Project: Retail Tenancy 5 – Overseas Passenger Terminal

Report: BCA & Access Assessment Report

Reference No: 107134-BCA-r3

Date: 10 October 2016

Level 1 Proposed
1:200 @ A3
July 2016
SK
257_ADA_012 F

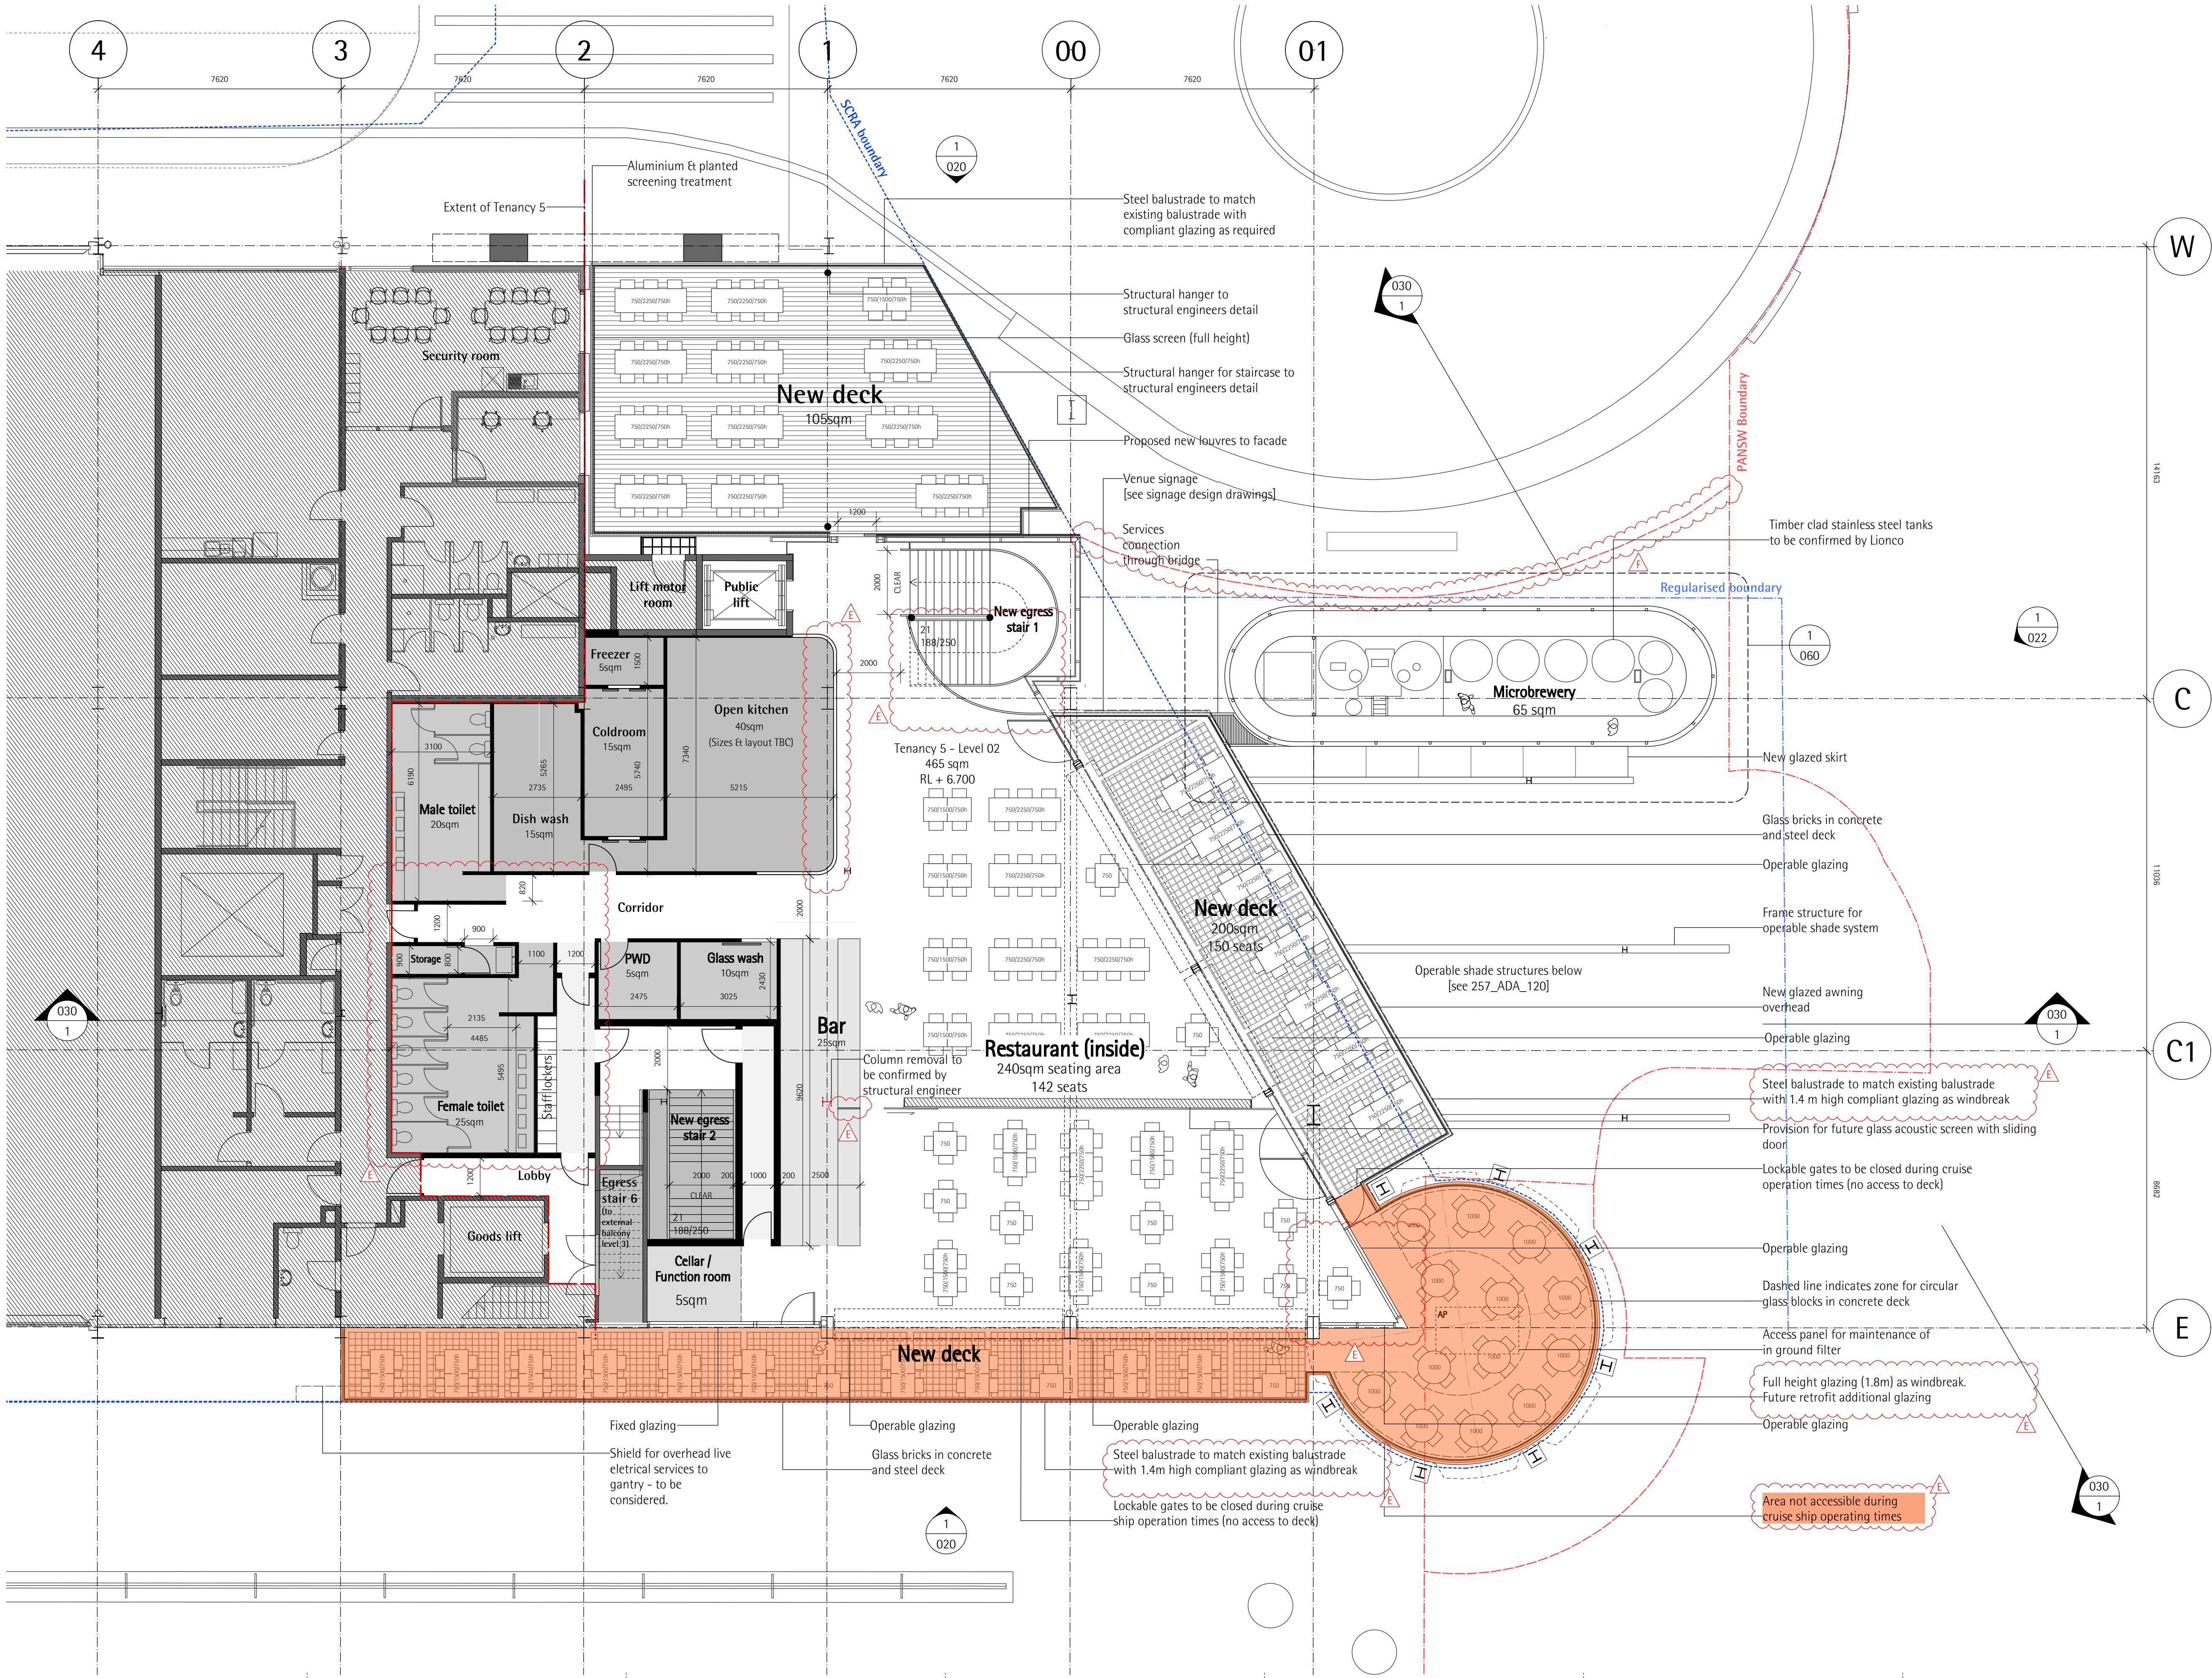
The unobstructed width of doorways is required to be no less than 750 mm, unless providing access for people with disabilities in which case the unobstructed width must be not less than 850 mm.

Level 1:
